EPC STORMWATER REVIEW COMMENTS
IN ORANGE BOXES WITH BLACK TEXT

FALCON AREA WATER/WASTEWATER AUTHORITY

BAR-X PIPELINE SEGMENT A2 EROSION CONTROL

PCD File No. **CDR248**

SHEET NUMBER
EC-06

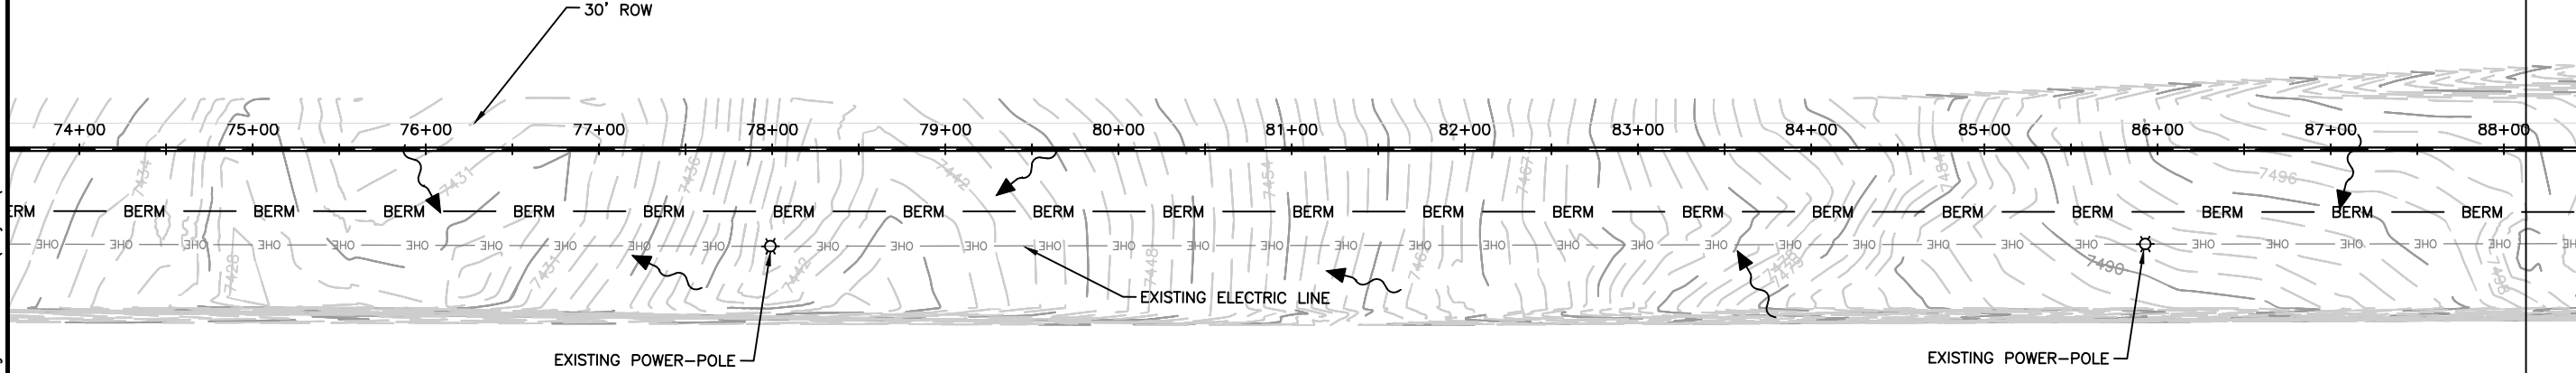
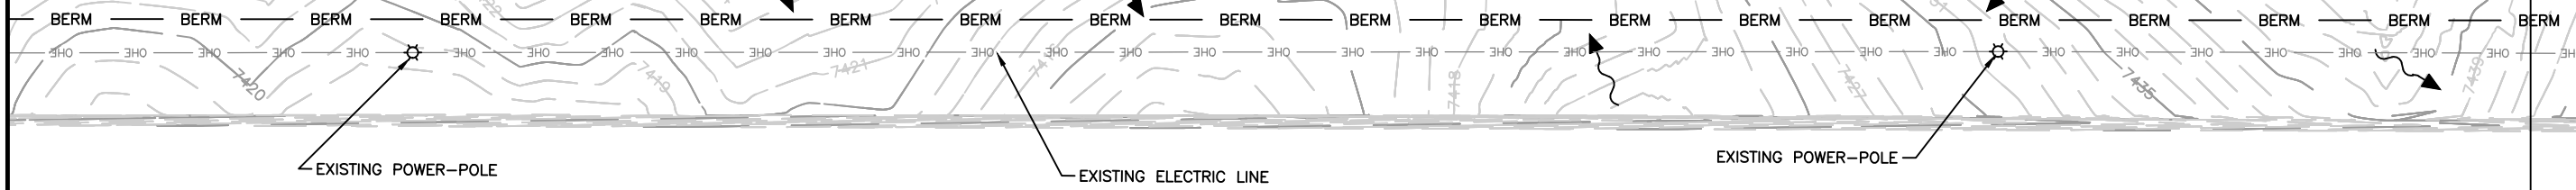
This appears to be a low spot along the proposed berm BMP. The berm at this location should be broken up and because flow will concentrate here riprap or other dispersement method likely is required to prevent erosion. Typical comment for all low spots.

This appears to be a low spot along the proposed berm BMP. The berm at this location should be broken up and because flow will concentrate here riprap or other dispersement method likely is required to prevent erosion. Typical comment for all low spots.
